## **BUILDING CODE OF AUSTRALIA REPORT**

**Mixed Use Development  
Site 9 – Sydney Olympic Park**

## BCA ASSESSMENT REPORT

Corner of Olympic Boulevard and Sarah Durack Avenue, Olympic Park - Site 9

**General Arrangement Plan  
Ground**

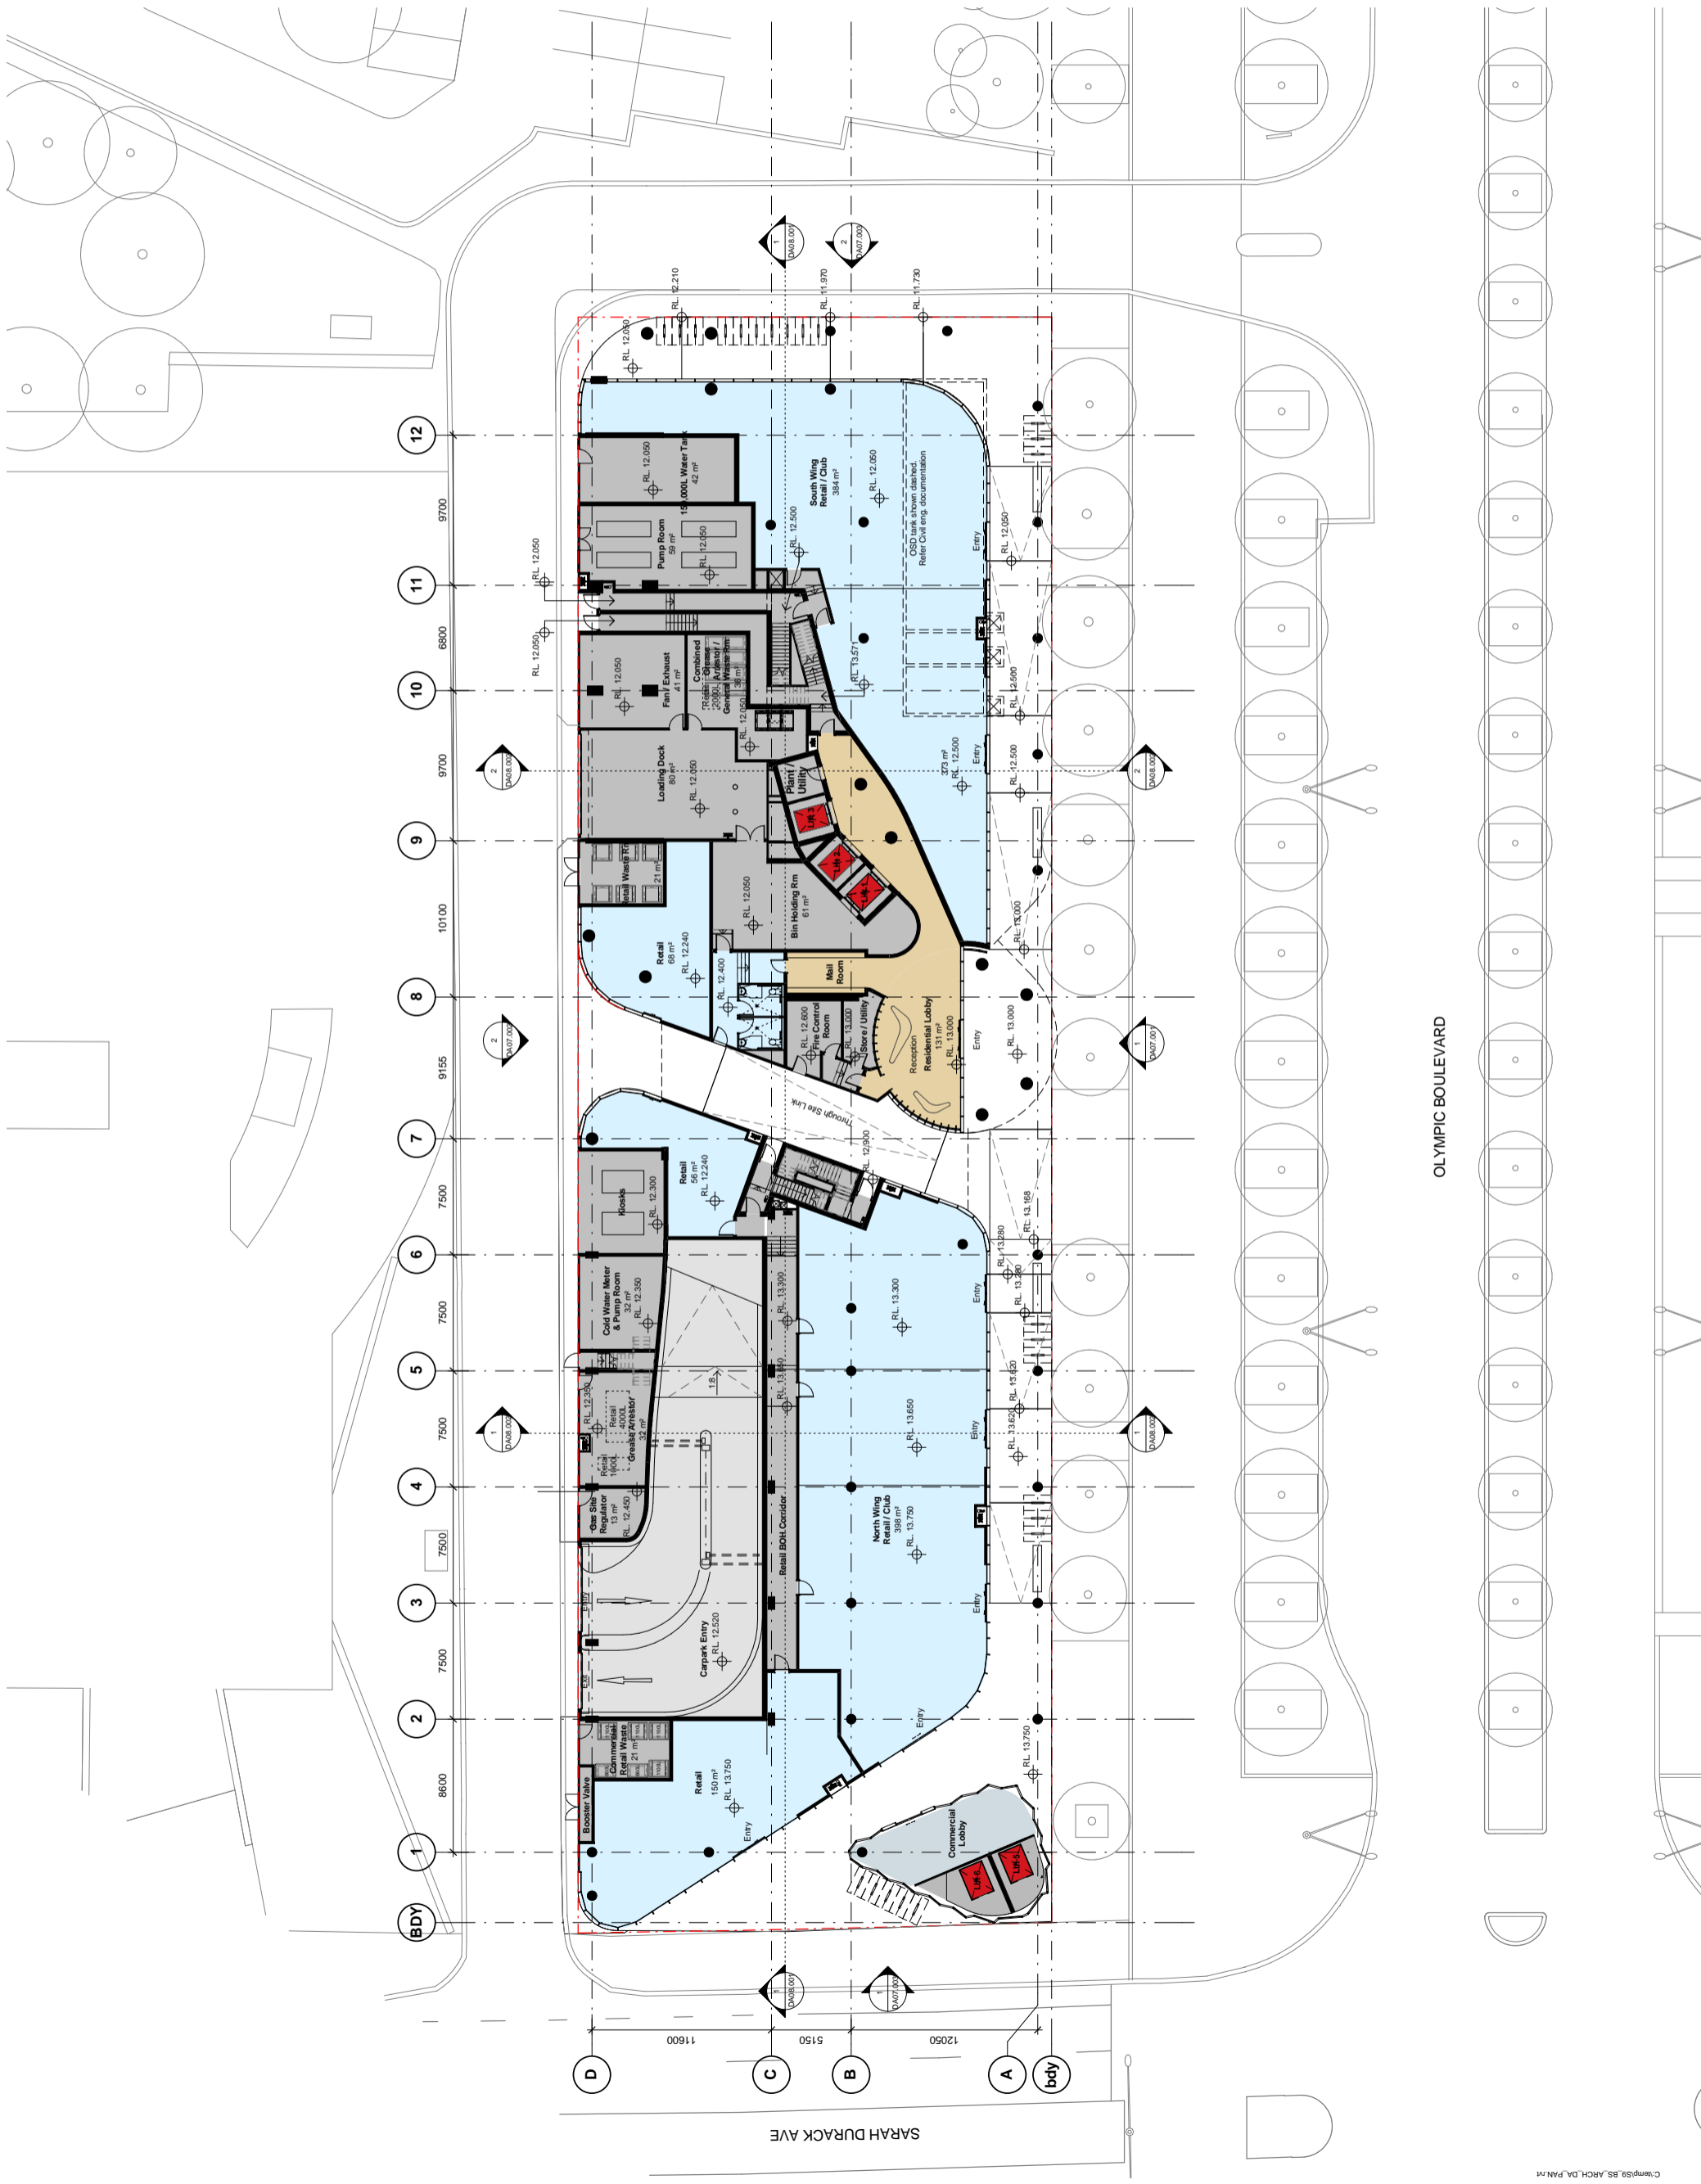
- FRL's to be reduced from 180minutes to 120minutes in the retails areas.

In addition to this the discharge points from the north and south wings lead to a covered site link which is less than 1/3 open.

- $4.6+13.2+4.7+13 = 35.5\text{m}$  perimeter of covered site link
- $1/3$  perimeter = 11.84m
- $4.6+4.7 = 9.3\text{m}$  open < 11.84m required

This will be required to be addressed as part of the fire engineered solution for the proposal.

General Arrangement Plan  
 Level 03

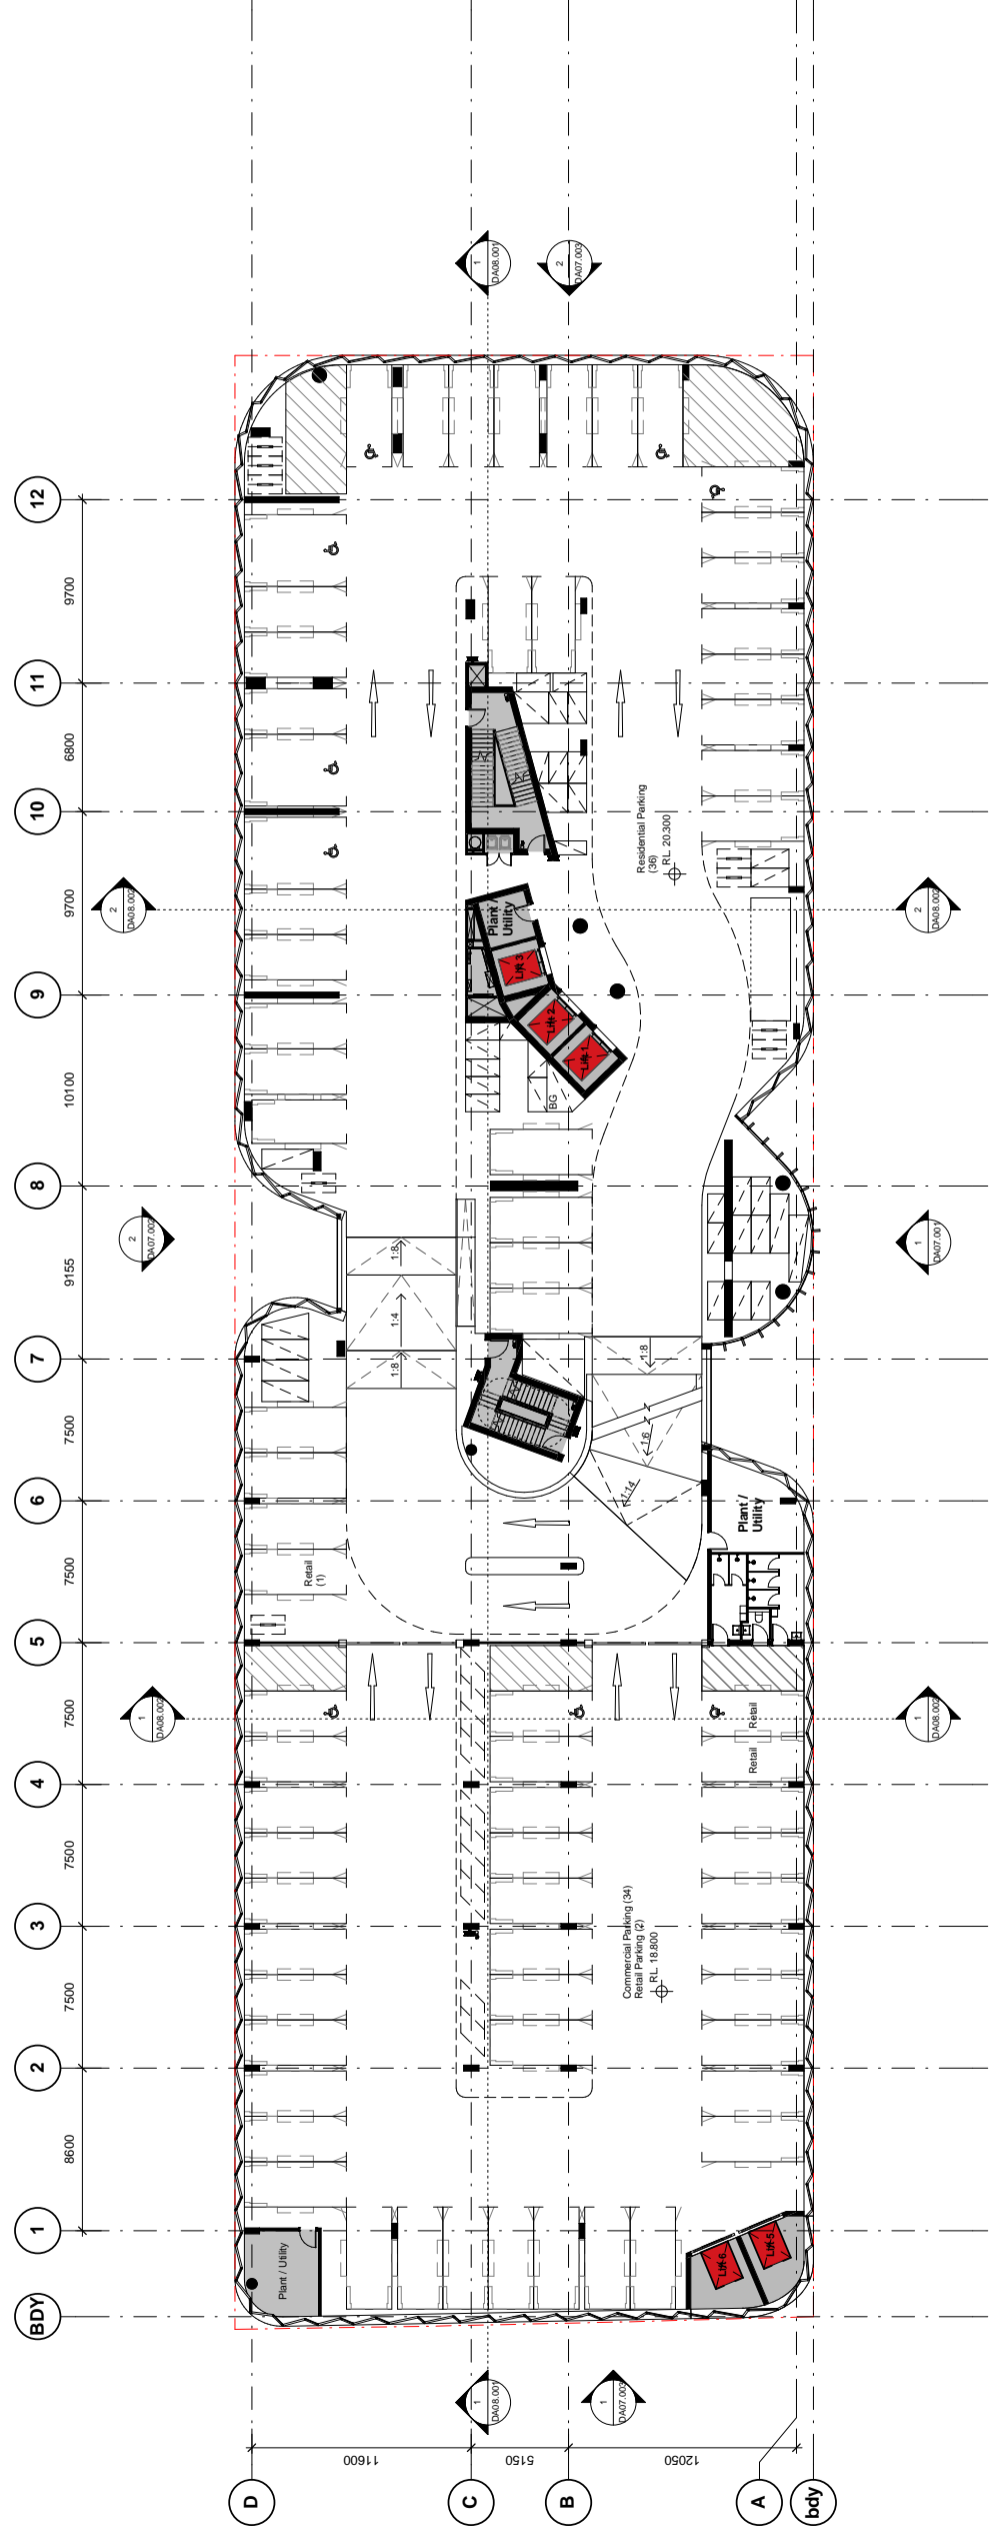
Level 3 (commercial)

- Travel distance is up to 53m in lieu of 40m where 2 exits are available

General Arrangement Plan  
 Level 04

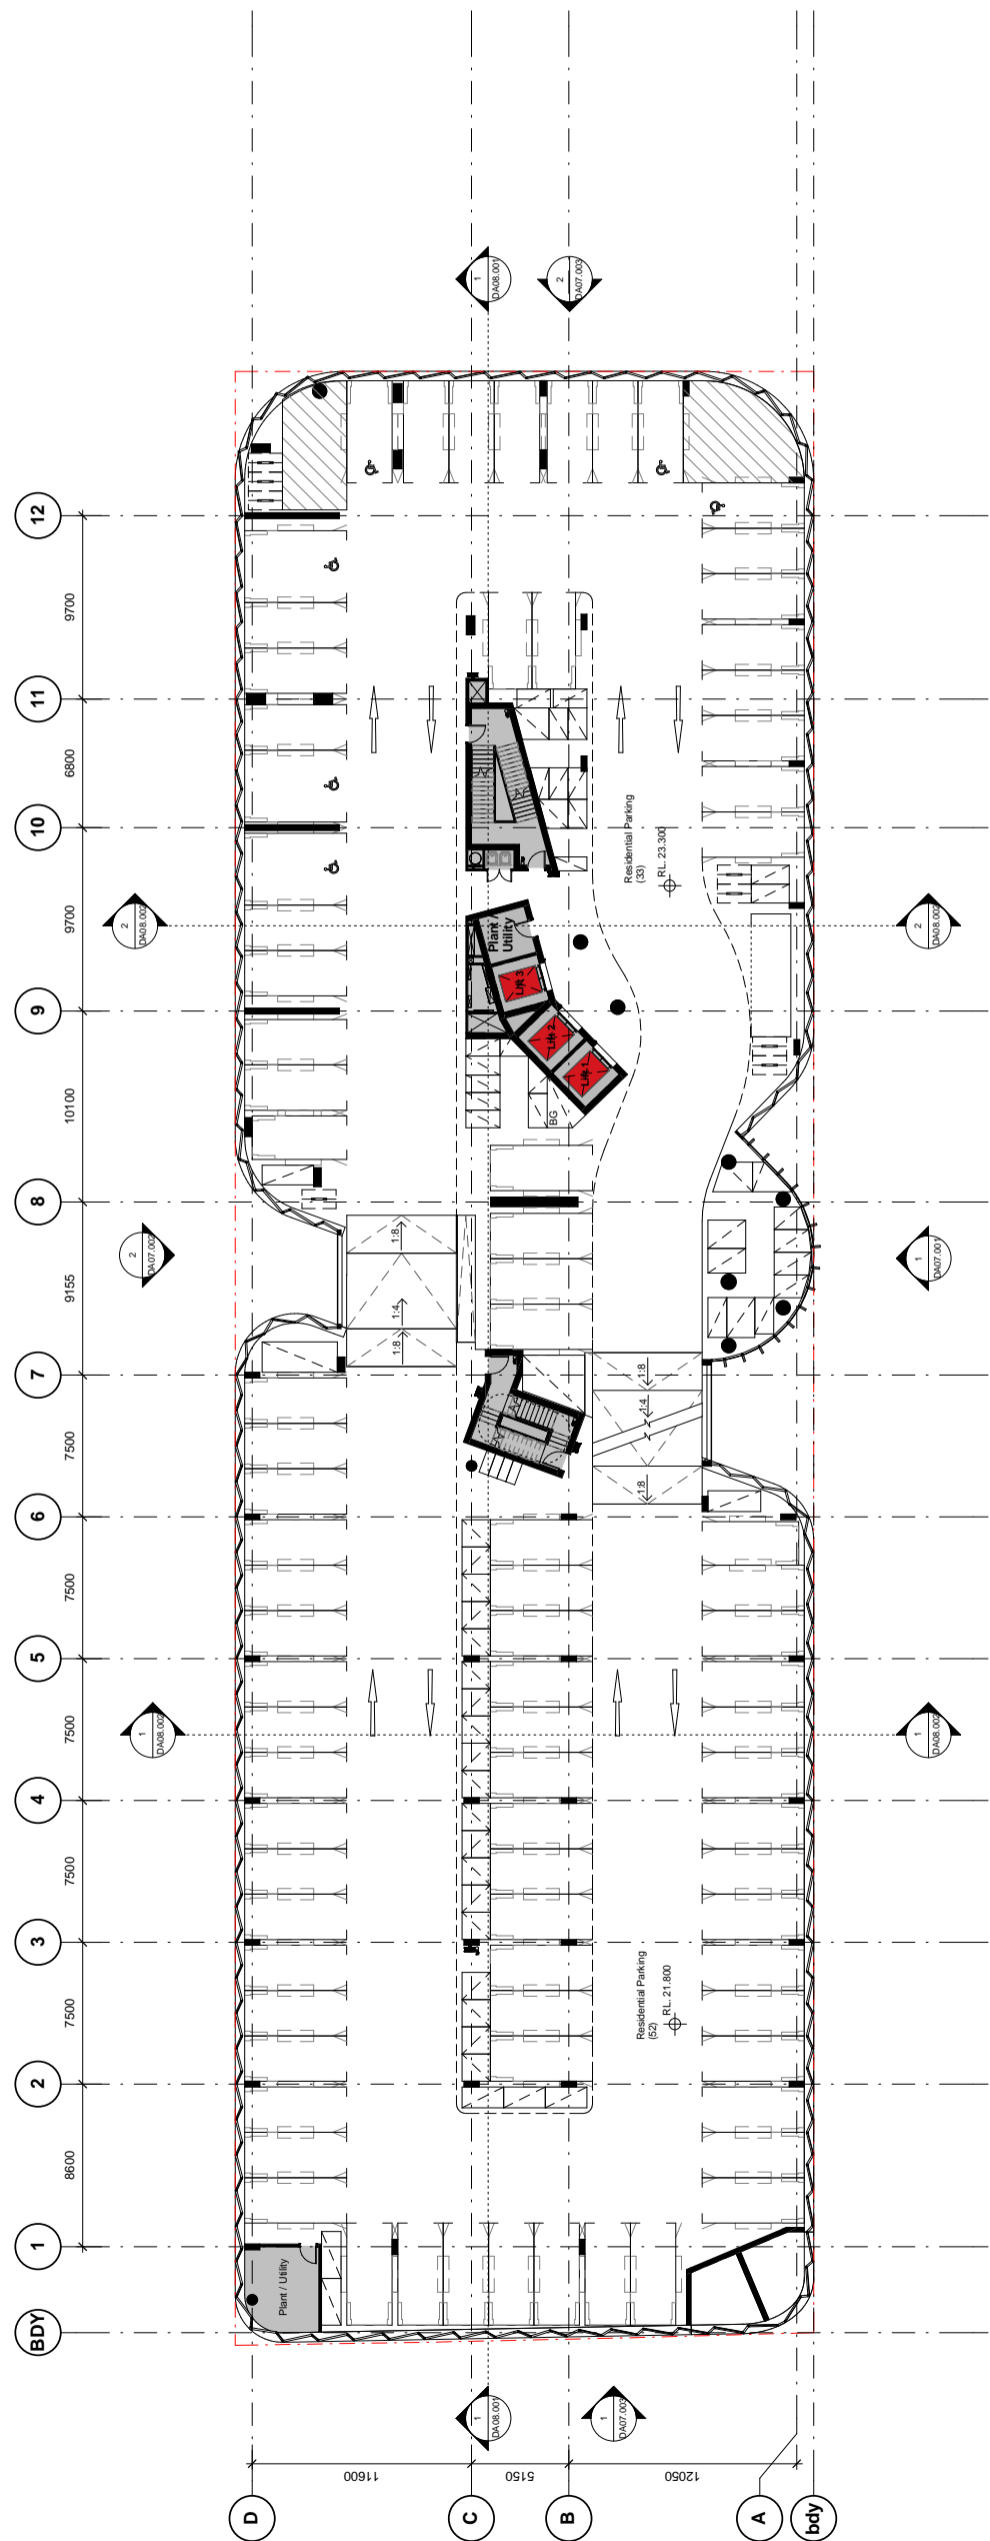
Level 4-6 (residential)

- Travel distance is up to 53m in lieu of 40m where 2 exits are available

**General Arrangement Plan  
Level 07**

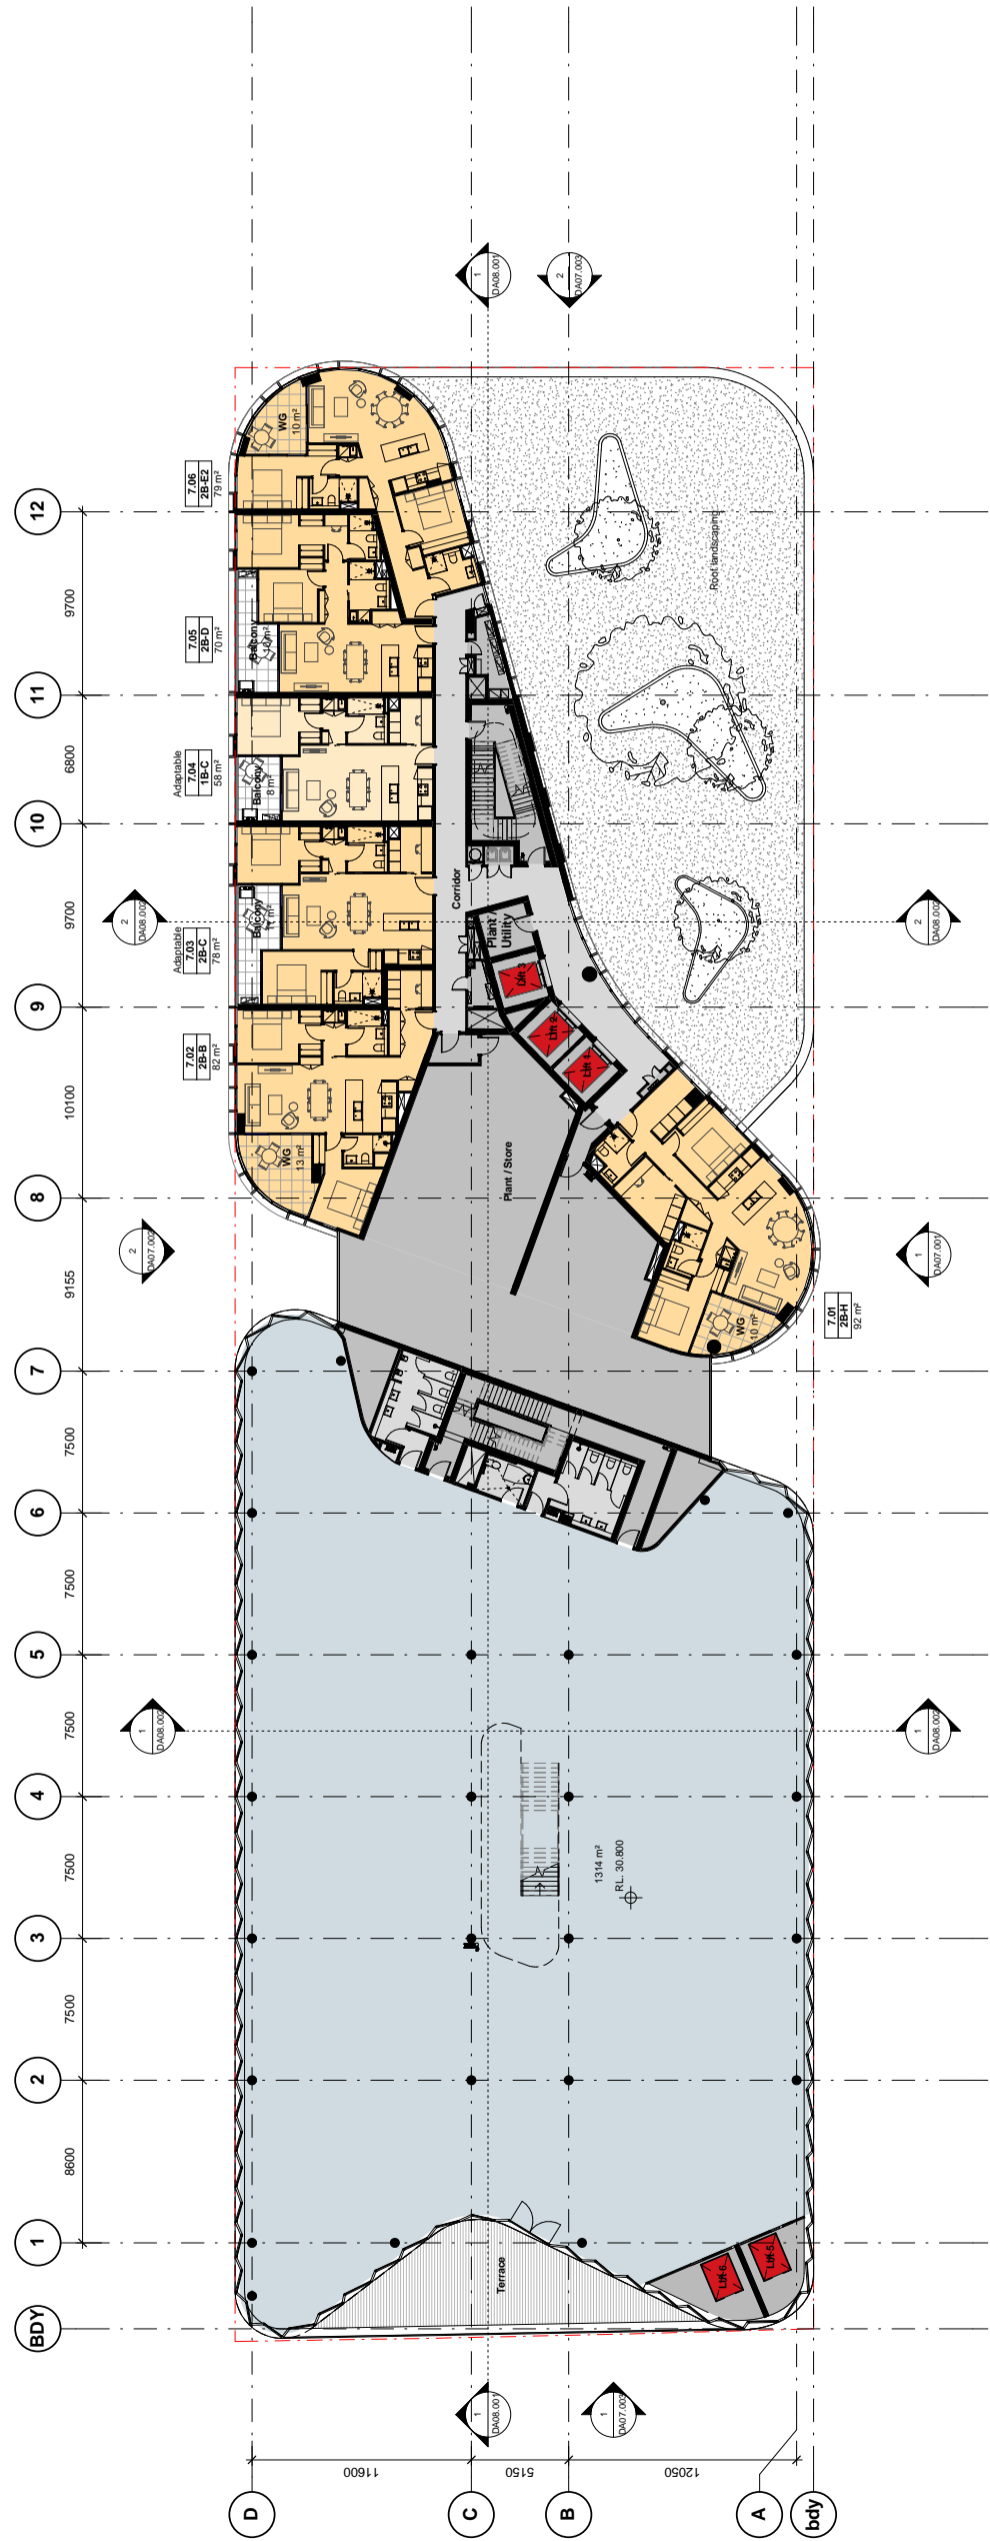
- Travel distance is up to 48m in lieu of 40m where 2 exits are available (this is without fixtures being detailed which will increase the travel distances)

- Travel distance is up to 27m in lieu of 20m from within non-SOU area.
